January 10, 2024

Site: San Pedro Apartments at 9320 San Pedro Dr. NE (C18E108) – NMR10055P

Re: Drainage Ordinance (14-5-2-11) Violations for Erosion and Sediment Control

GTA SAN PEDRO, LLC
SAN PEDRO APARTMENTS
TESCP

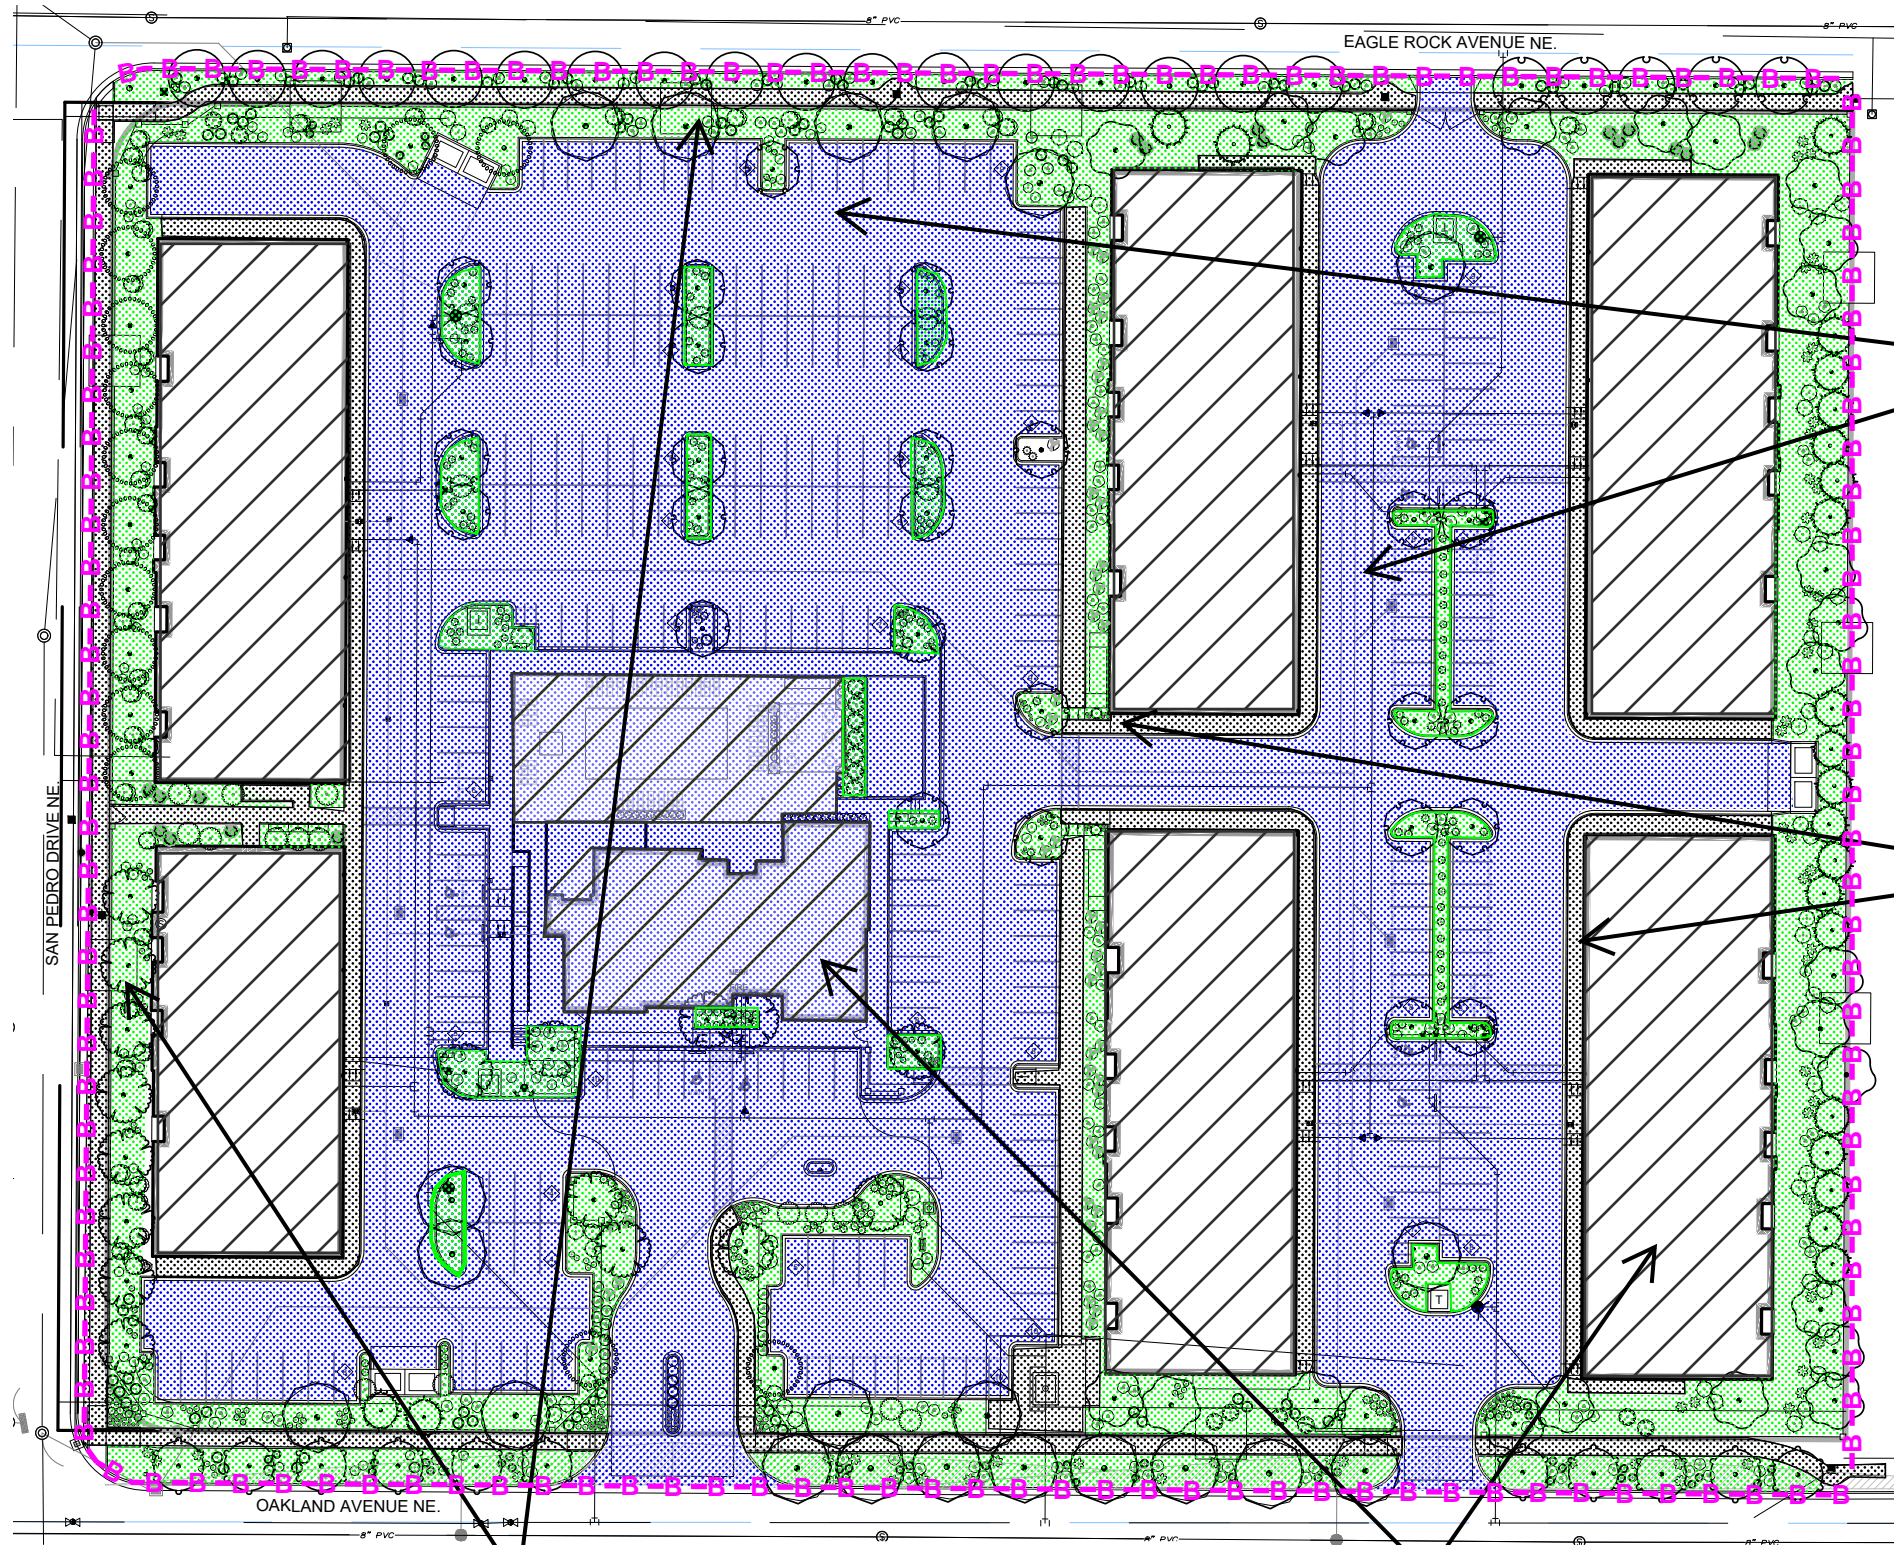
1. **Sediment** – There is sediment along all three City roads that surround the perimeter of the site. The construction exit is not minimizing sediment track-out onto Oakland Ave. in violation of CGP Part 2.2.4. Vehicles are cutting the corner of the construction exit rock causing additional track-out. The disturbances outside of the perimeter construction fencing has also produced sediment deposit along San Pedro Dr. and Eagle Rock Ave. Sediment track-out has been observed and reported on each of the previous three City inspections; additional measures will be needed to minimize track-out.

2. **BMPs** – Multiple storm drain inlets either have no protection or the protection is in poor condition in violation of CGP Parts 2.2.10 and 2.1.4. The unprotected storm drain inlets are located throughout the site and along the City roads around the perimeter of the construction site.

4. **Stabilization** – The disturbance along Eagle Rock Rd. has been inactive for over 14 calendar days without temporary or permanent stabilization measures in violation of CGP Part 2.2.14.

1. **Sediment** – You are required to minimize sediment track-out per CGP Part 2.2.4. Use appropriate stabilization techniques at all points that exit onto paved roads. *You must implement additional track-out controls as necessary to ensure that sediment removal occurs prior to vehicle exit.* Where sediment has been tracked-out from your site onto paved roads, sidewalks, or other paved areas outside of your site, remove the deposited sediment by the end of the same business day in which the track-out occurs. Remove the track-out by sweeping, shoveling, or vacuuming these surfaces. You are prohibited from hosing or sweeping tracked-out sediment into any constructed or natural site drainage feature, storm drain inlet, or receiving water.

2. **BMPs** – Install inlet protection measures that remove sediment from discharges prior to entry into any storm drain inlet. Inlet protection should create ponding upstream of the inlet without blocking the inlet. Clean, or remove and replace, the protection measures as sediment accumulates. Remove sediment by the end of the business day per CGP 2.2.10. Ensure that all stormwater controls (BMPs) are maintained and remain in effective operating condition during permit coverage per CGP 2.1.4. If at any time you find that a stormwater control needs routine Maintenance, you must immediately initiate the needed maintenance work and complete such work by the close of the next business day. When the problem requires a new or replacement control or significant repair, install the new or modified control and make it operational, or complete the repair, by no later than seven (7) calendar days from the time of discovery per CGP 5.2.1.

4. **Stabilization** – Initiate the installation of stabilization measures immediately in any areas of exposed soil where construction activities have permanently ceased or will be temporarily inactive for 14 or more calendar days and complete the installation of

stabilization measures as soon as practicable, but no later than seven calendar days after stabilization has been initiated per CGP Part 2.2.14.
